DRB Application No.: 07DRB-00089 (SBP)

Project Name: PEREA ADDITION

**SUBJECT: LITTLE BROTHERS OF THE GOOD SHEPARD**  
**LOT 1-A, BLOCK 45, PEREA ADDITION**  
Project 1005189  
ZAP J-13

AC1

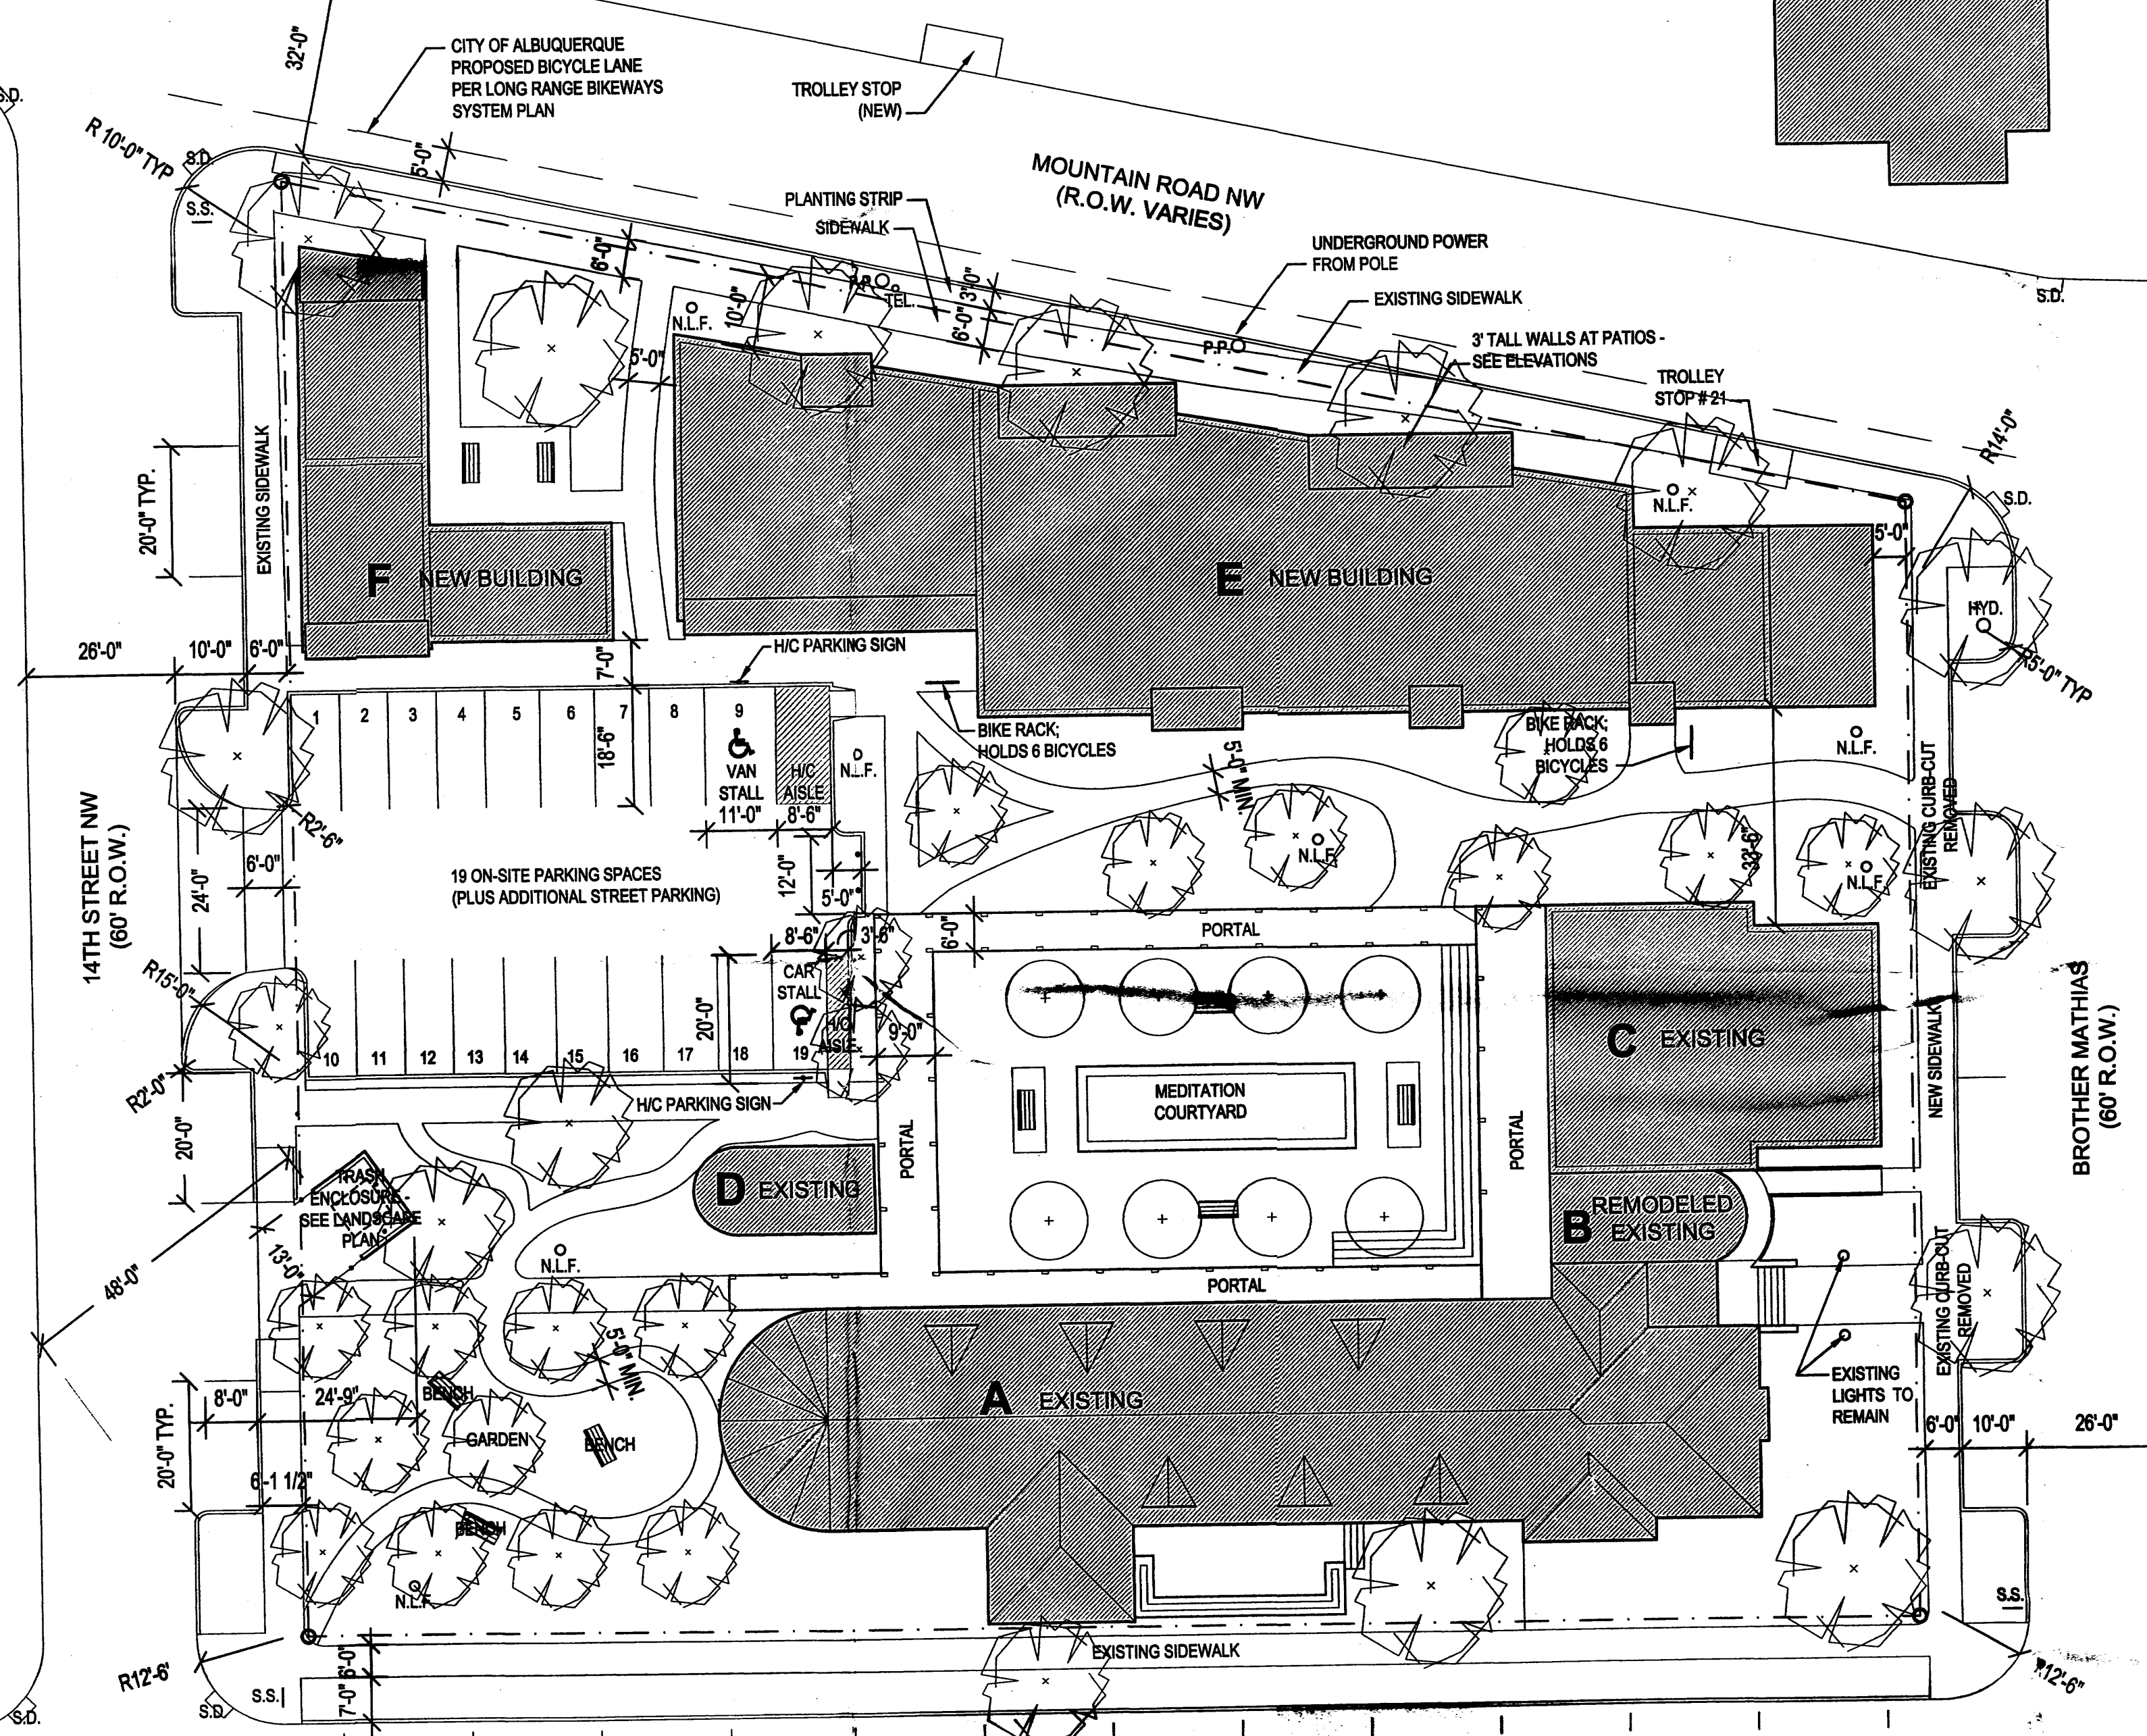
1. The off-site parking is not necessary to satisfy the parking requirement for the project, therefore, it has been removed from the plan.
2. Since the off-site parking is not a part of the project, all references to the perimeter street work have been removed from the plan.
3. A 6 foot bike lane will be striped along the Mountain Road frontage as requested. This item is reflected on the Infrastructure Listing.
